## PROPOSED 5 DWELLINGS, LAND AT AND ADJACENT TO 88 WORSLEY ROAD, NEWPORT – ACCESS STATEMENT

## PRE-APPLICATION ADVICE

Location: Land at and adjacent to No. 88 Worsley Road. Newport

Proposal: Residential Development and associated vehicle access

drawing number 25905/01 | rev. A

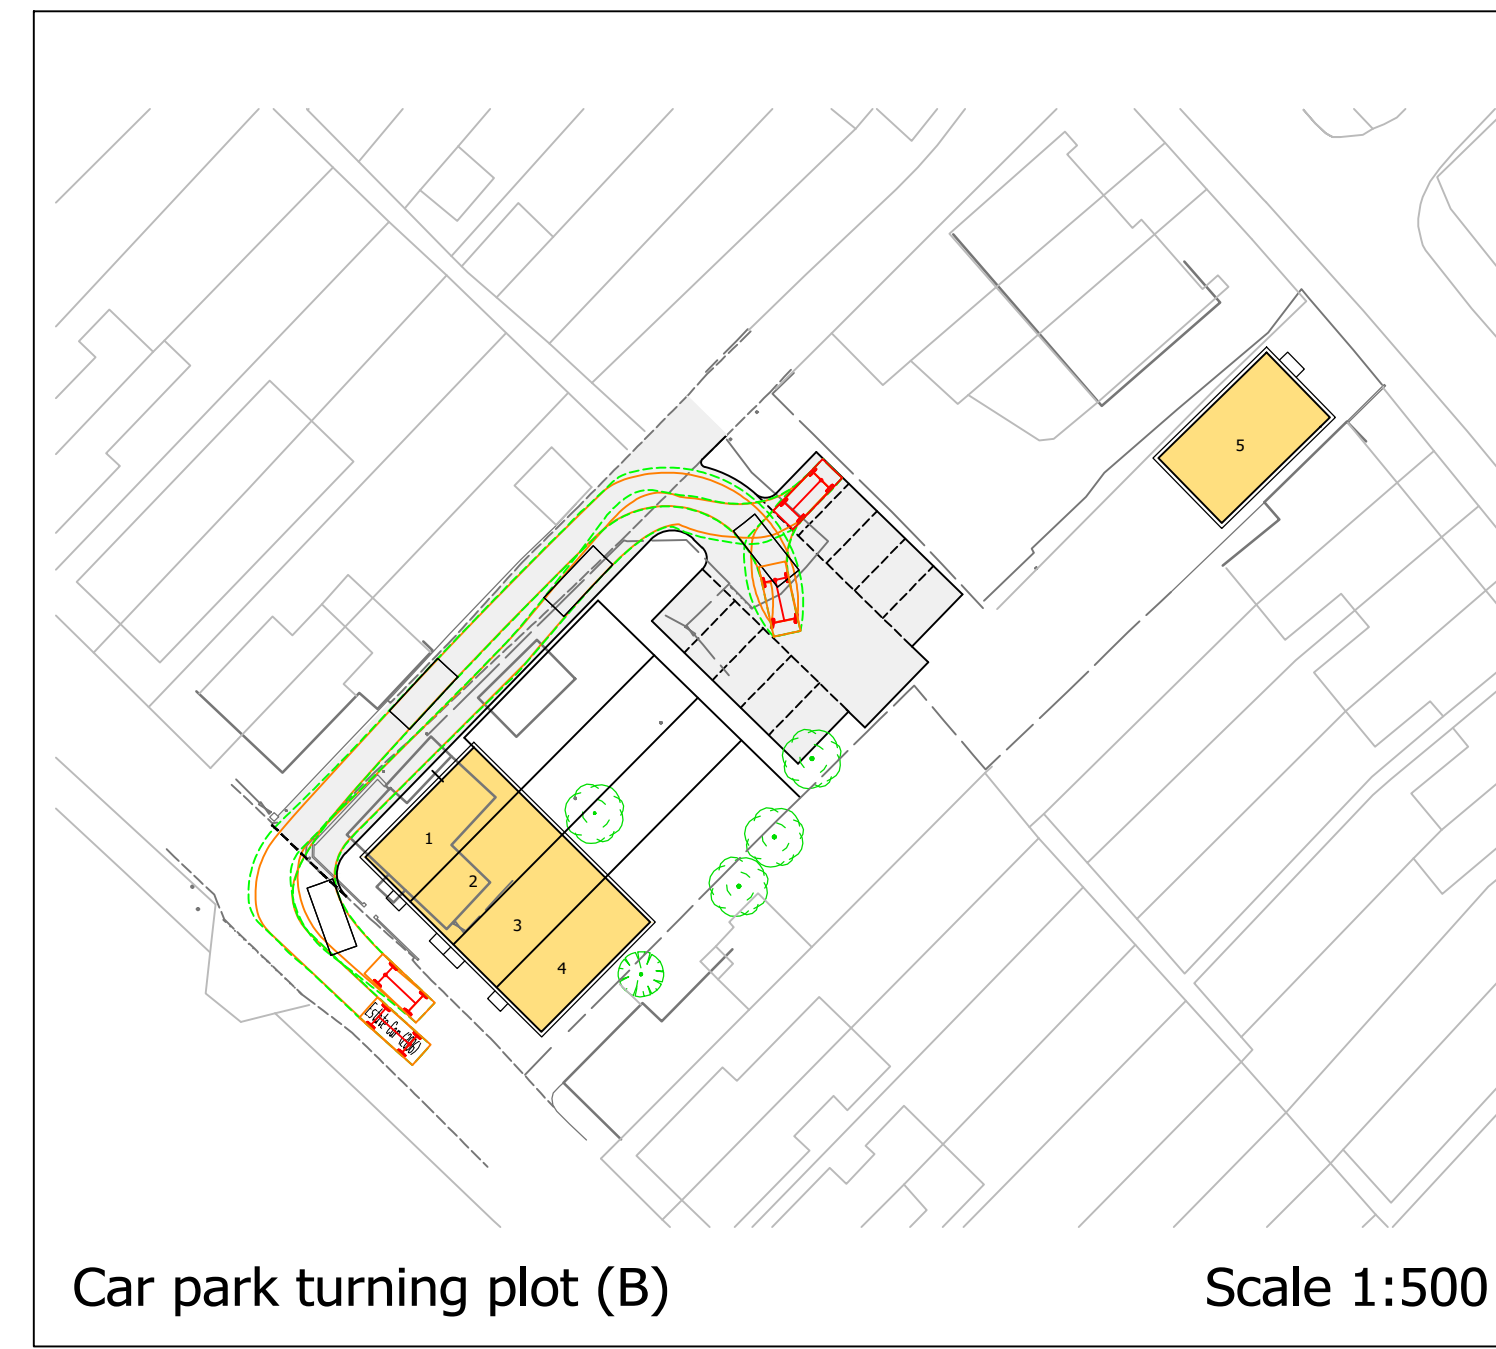
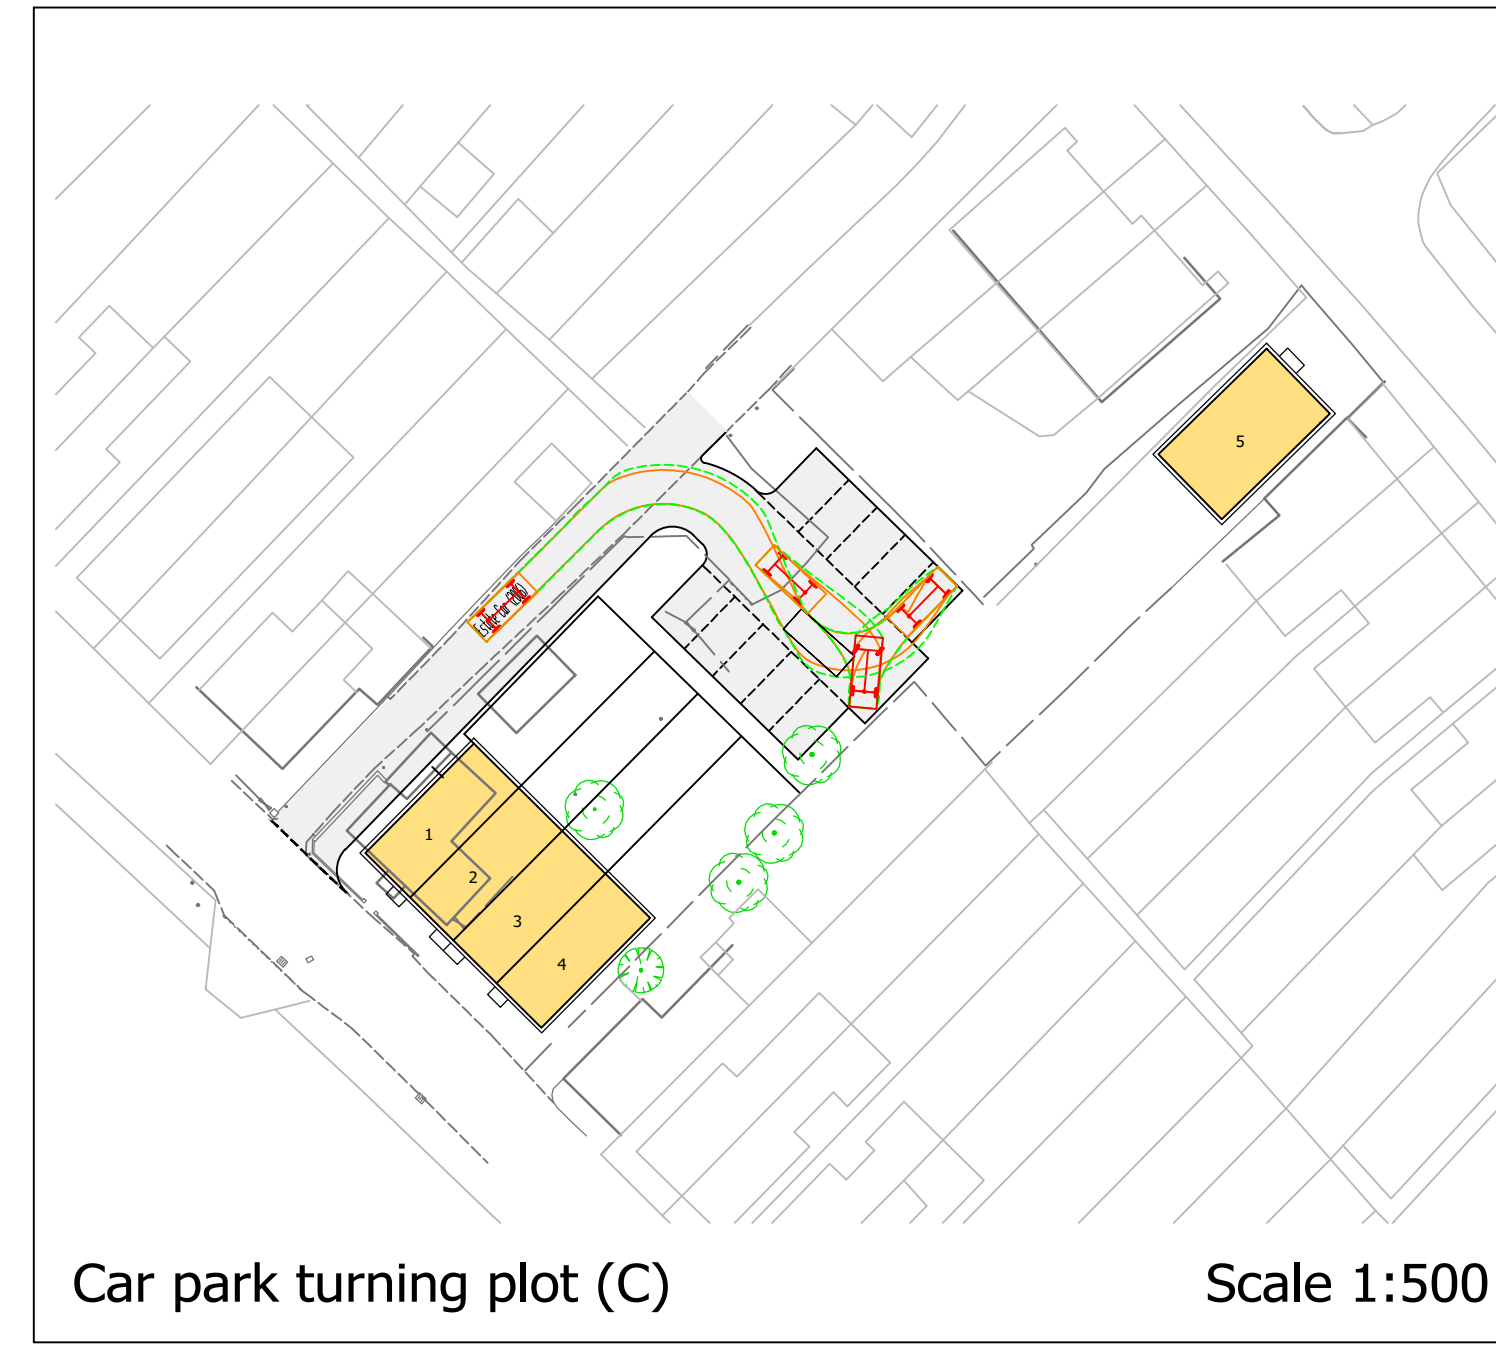
Looking specifically at the proposed layout you have provided in respect to Option 1 question is raised in respect to the ability to provide the required level of access visibility at each of the proposed access points. The layouts would appear to indicate that each of the access points

could be accessed and egressed by a conventional private motor vehicle however again concern is raised that those proposed to be formed onto Worsley Road (Units 1 and 4) could be hindered by existing on-street parking practices and their proximity to Chalky Lane. The proposal is also devoid of any pedestrian provision.

In relation to Option 2 the principal of a shared car park served by a single access off Chalky Lane is accepted. However, the access will need to comply with the highway design standard as listed above allowing for two conventional private motor vehicles to pass and any formal submission will need to be supported by a swept path analysis evidencing that all parking bays could be accessed and egressed with ease when the others were occupied.

It is acknowledged that you make reference to bringing forward some offsite highway improvements / junction remodelling as part of Option 2, due to the existing limitations of Chalky Lane and its junctions. However, this office sees it to be essential that the proposal include for the widening of Chalky Lane along its entire length and at each of its junctions with provision also being made for associated visibility improvements and pedestrian linkage through to the existing public footway network on Albany Road. Localised carriageway widening in isolation is not seen to be acceptable as it could result in additional highway safety issues being created on this part of the highway network with it not only being used by residents of the proposed development but also having the potential to encourage more existing local network users to use it.

8. Therefore, it is considered that the optimum arrangement is to provide a shared parking area in the centre of the site, with access from the lane linking Worsley Road and Albany Road, known locally as Chalky Lane. The proposed layout is shown on **Drawing No. 25905/01 Rev. A**.

9. 10 parking spaces are proposed, i.e., 2 spaces per dwelling; this exceeds the Council's minimum requirement for 2-bedroom houses and should avoid putting additional pressure on on-street parking space.

10. Chalky Lane is currently only 2.7m wide at its western end. It is proposed to widen it to 4.8m between Worsley Road and the car park entrance, enabling two cars to pass, with the car park entrance being aligned to encourage entry and exit from/to Worsley Road rather than Albany Road; that restriction is not enforceable, but it seems unlikely that residents would usually choose the more difficult manoeuvre to or from Albany Road.

11. The widening of the lane, combined with the removal of the existing boundary wall in front of no. 88, will also improve junction visibility onto Worsley Road, particularly to the south where a splay of 2.4m x 33m can be achieved, meeting the recommendation in Manual for Streets for a traffic speed of 25mph. (Island Roads have accepted that the prevailing speeds in this area may well be closer to 20mph). To the north, the sightline is restricted by the neighbouring property, but a small improvement will still be realised in that direction due to vehicles emerging from Chalky Lane being positioned slightly further to the south than they are now.
